EP-21-0083 Crystal Park Site S-178R (Miller Residence)

The applicant proposes a single-family residence at 5050 Neeber Valley Road in the Crystal Park development. With this resubmittal, we received the Site Plan (LGA Studios, October 6, 2021) and Response to Colorado Geological Survey Comments (Geoquest, LLC, stamped September 24, 2021).

Submitted 10/21/2021 by Amy Crandall, Engineering Geologist, Colorado Geological Survey (303-384-2632 or [acrandall@mines.edu](mailto:acrandall@mines.edu))

Name : Final Construction - Lower Wall Stability

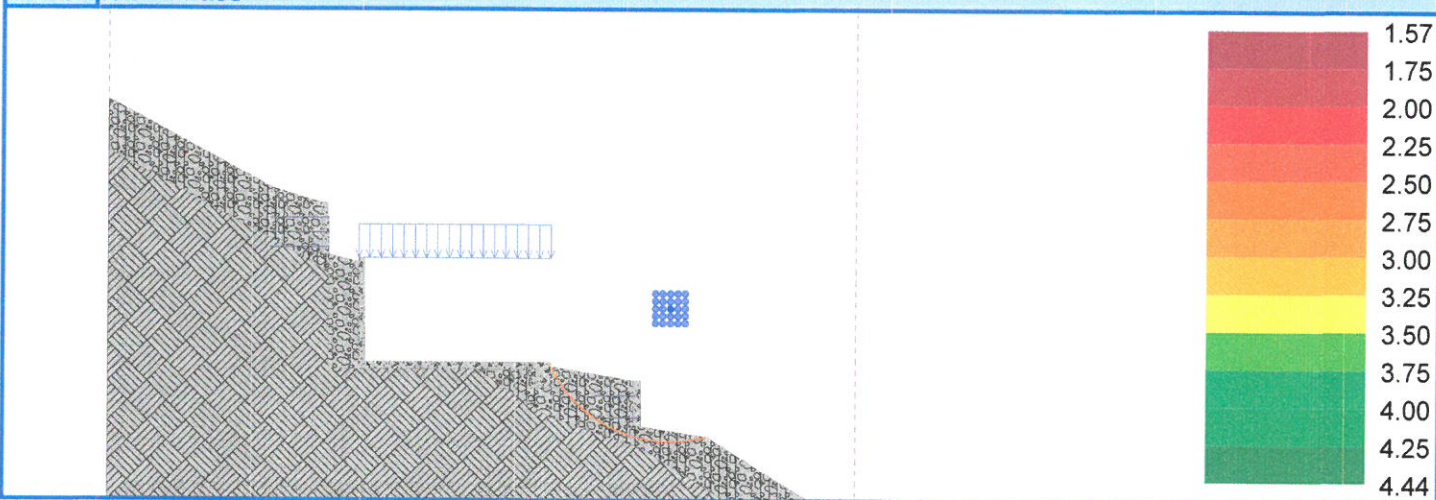
2. *Geoquest's analysis yielded a Factor of Safety (FOS) less than industry standards for the existing slope, maximum construction slope, upper wall stability, and downslope stability. The calculated FOS meets industry standards of 1.5 for the lower wall stability and final construction – global slope stability.*

I agree with Geoquest that a licensed Colorado Professional Engineer should design the upper wall stability (and lower wall stability) and achieve a factor of safety greater than 1.5.

Name : Final Construction - Downslope Stability

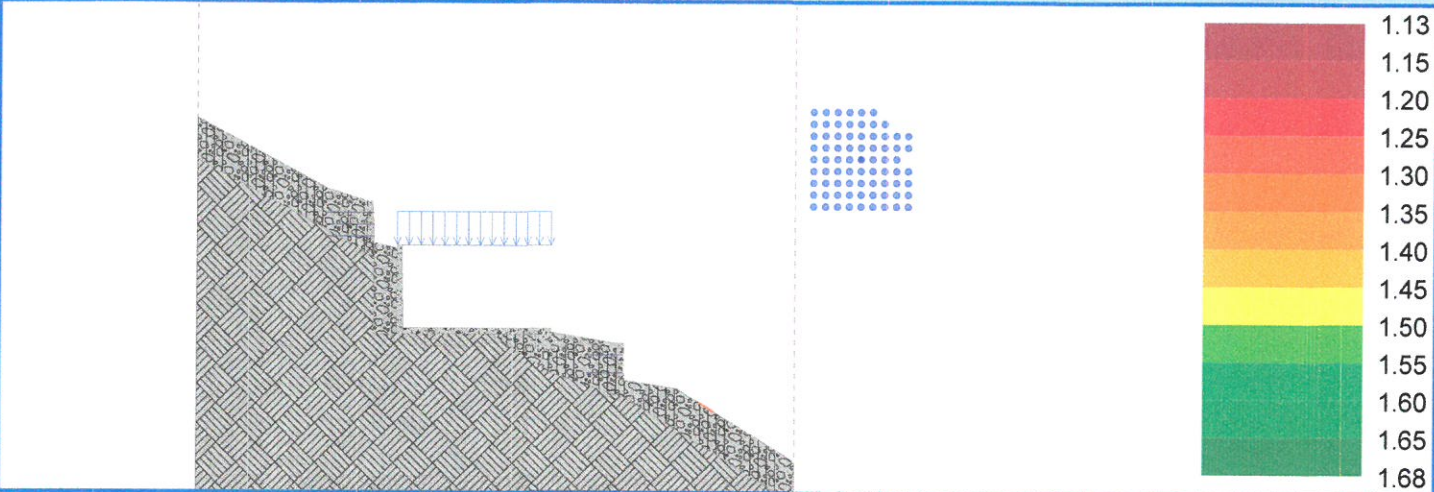
In Geoquest's June 21, 2021 report, the upper level stability (Stage – analysis: 1-1) yielded a factor of safety of 1.13. Geoquest states in their response letter, "The native downslope stability has a factor of safety of 1.13 which matches the preconstruction stability downslope of the proposed structure." However, I cannot seem to find an "initial downslope stability" analysis and am unsure how Geoquest concluded, "The proposed construction has no impact on the native slope stability past the area of disturbance."

Sheet #
SP1
OF 1 Sheets

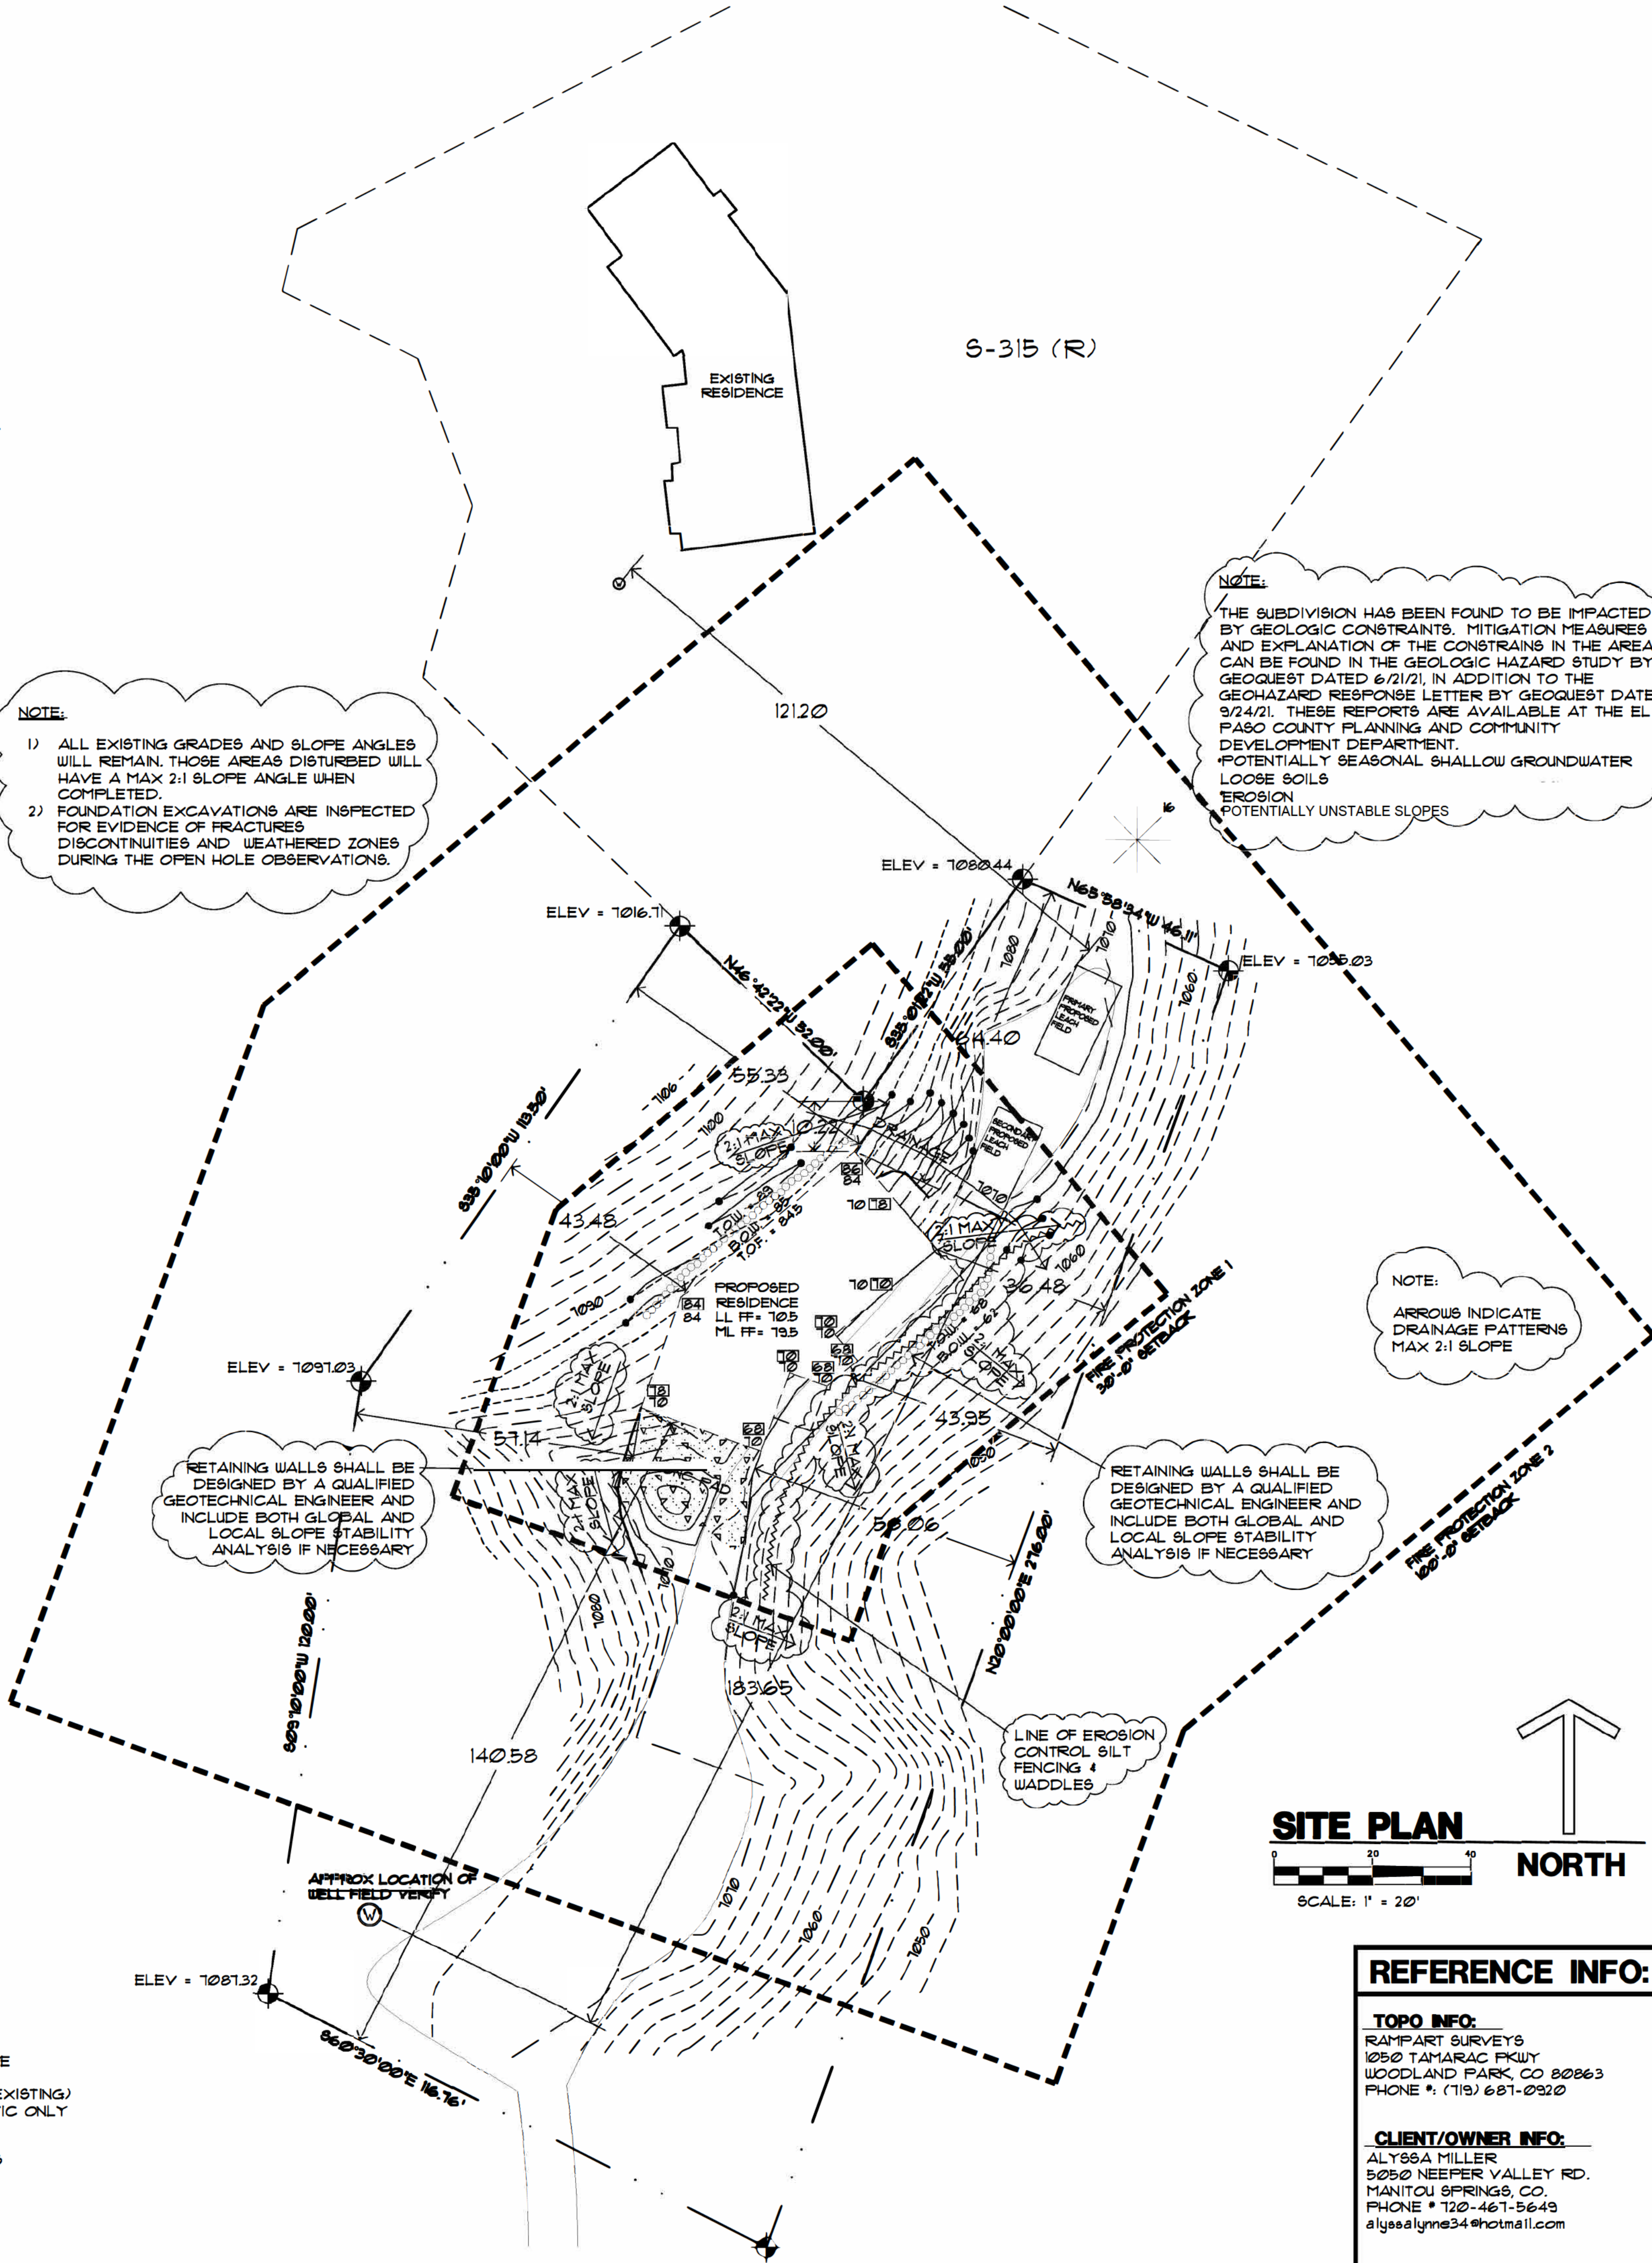
1. *As noted on page 2 of Geoquest's geologic hazard report, "we recommend slopes not exceed 2:1 (horizontal:vertical). Slopes steeper than this are subject to localized slope failure." However, it appears that these slopes are exceeded in the slope stability analysis with local slope failures shown. Recommended slope angles should be noted in the site plan.*

5. *As recommended by Geoquest, “Retaining walls should be designed by a qualified geotechnical engineer.” Also, “The retaining wall designer should check for local and global slope stability.” The recommendations we provided above for the slope stability analysis should also be applied to the retaining wall design.*

6. *CGS recommends that the project civil engineer design a drainage system that protects the subject property and properties further downslope from the flow of surface-generated water.*

7. *CGS recommends Geoquest or another qualified geotechnical engineer carefully inspect the foundation excavation for evidence of fractures, discontinuities, and weathered zones during the open hole observations.*

In addition, the geologic hazard note on the site plan indicates “potentially seasonal shallow groundwater, loose soils, and erosion”. Based on Geoquest’s geohazard report, potentially unstable slopes should also be included.

The maximum slope angles are noted on the updated site plan.

The revised site plan includes a note regarding the recommendation for retaining wall design.

Drainage patterns and erosion control protection are noted on the site plan.

The revised site plan includes a note (Note 2) regarding this recommendation.
